**Planning Department
Transportation Development Services Section**

Re: Certification Submittal for Certificate of Occupancy for
Plastic Machine Shop, 2601 Baylor Drive SE
Architect's Stamp dated 09-20-12 (M16-D037)
Certification dated 08-15-13

C3 ADA Curb Ramp
1/4" = 1'-0"

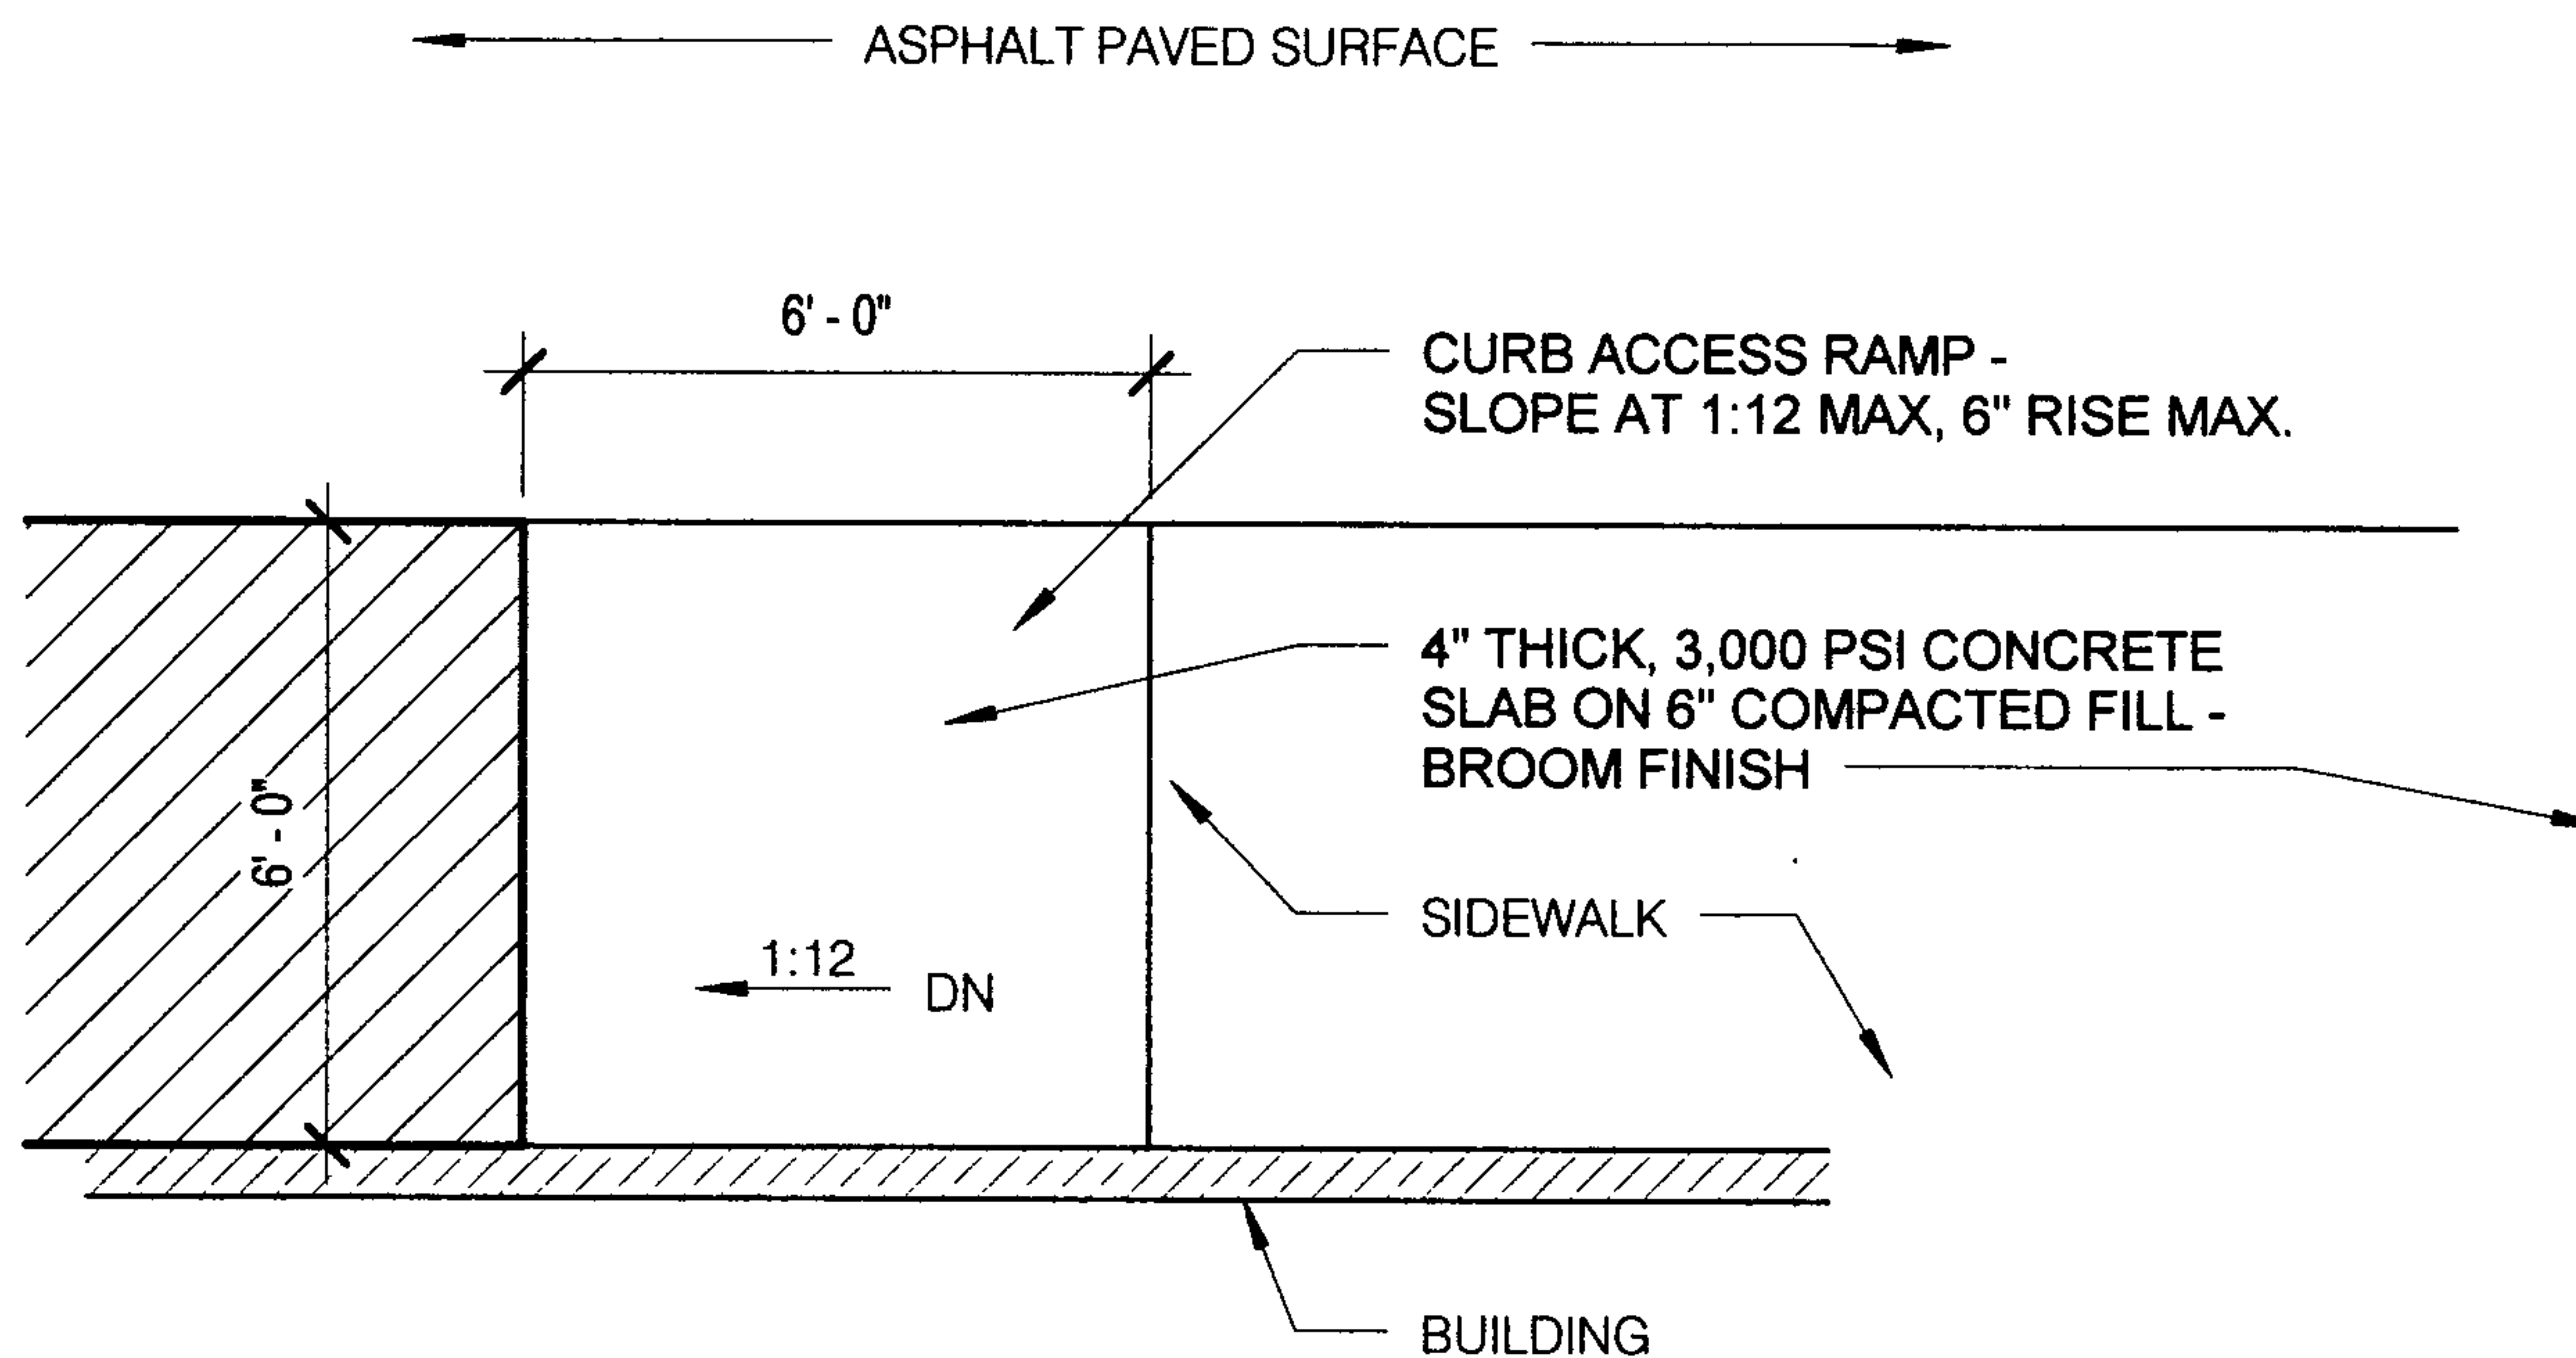
- At a recent site visit (08-16-13), it was noted that a number of items were not built with this project or were significantly modified, including curb and gutter, a hatched pedestrian pathway, and a 5-foot wide keyway. The certification must clearly show what has been built.
- The existing easternmost entrance was to be removed with this project and replaced with sidewalk and curb and gutter. This work has not yet been completed.
- An adequate keyway (5-foot depth minimum) must be provided for the deadend parking aisle.
- The new ADA parking stall does not meet minimum criteria (no access aisle, pathway is guided into traffic, etc.). Please remove this stall.
